Subject: 91 Hawthorn Road Bognor Regis PO21 2BE - BR/17/22/P

Planning Application Reference: BR/17/22/P

Proposal: Change of Use from hairdressers (Class E(a)) to Hot Food Takeaway (Sui Generis) with low level ducting system at the rear of the ground floor commercial unit. This site is in CIL Zone 4 (Zero Rated) as other development.

Location: 91 Hawthorn Road Bognor Regis PO21 2BE

SCHEMATIC DIAGRAM OF A KITCHEN VENTILATION SYSTEM LEGEND

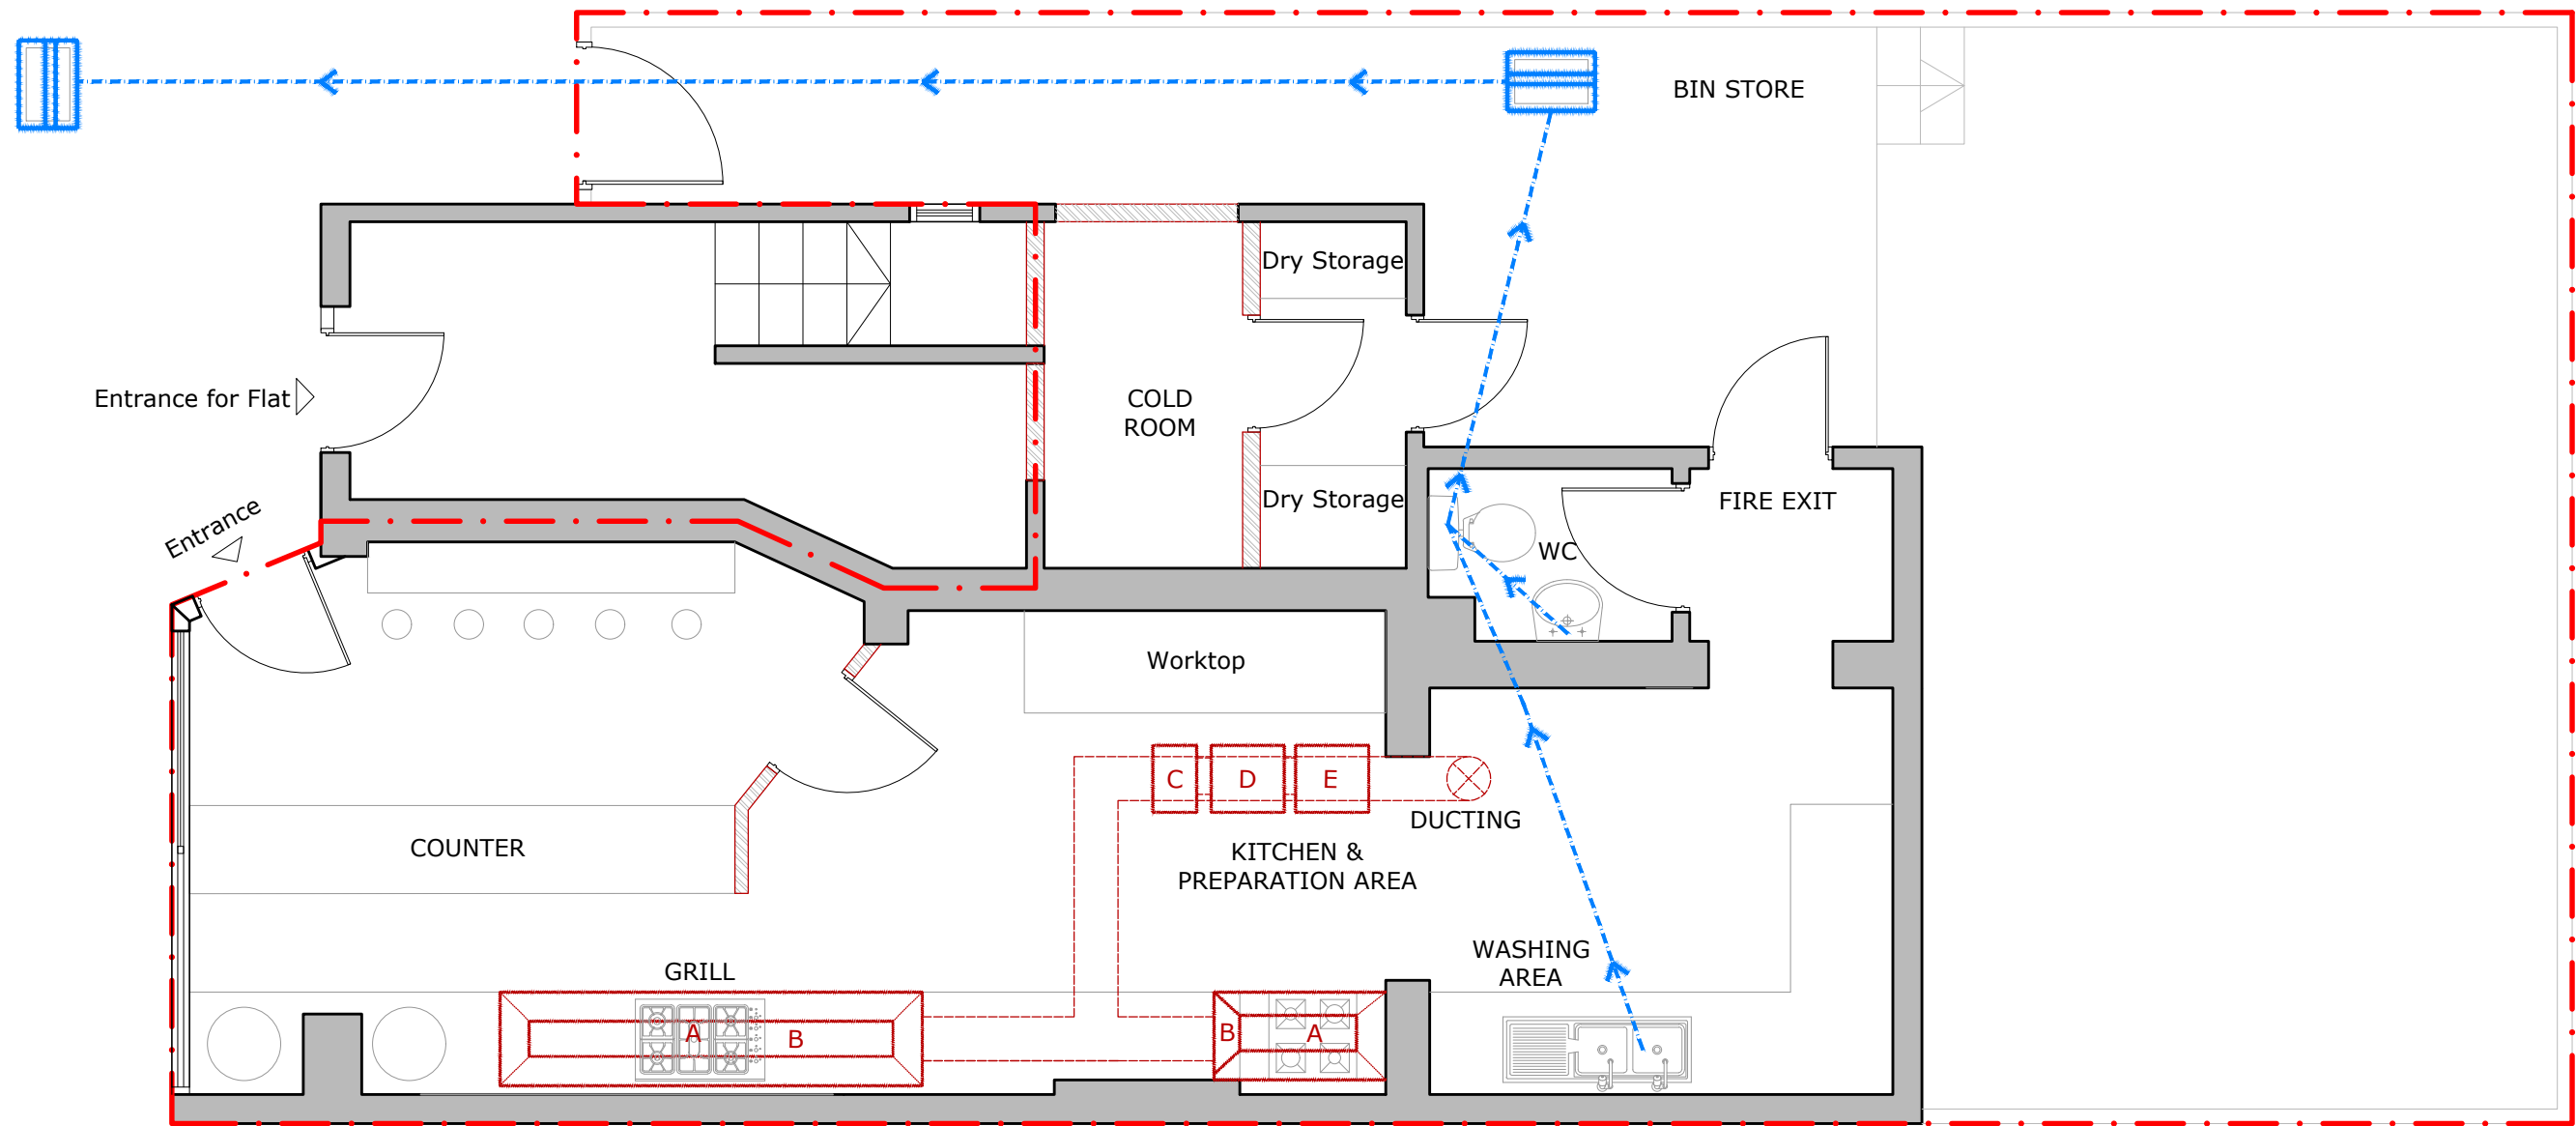
Extraction System

****Further information is required.****

I request the applicant carry out a risk assessment in accordance with EMAQ guidance document 'Control of Odour and Noise from Commercial Kitchen Exhaust Systems, 2018' to demonstrate that the proposed extraction arrangement shall be adequate to control odours from the proposed operation.
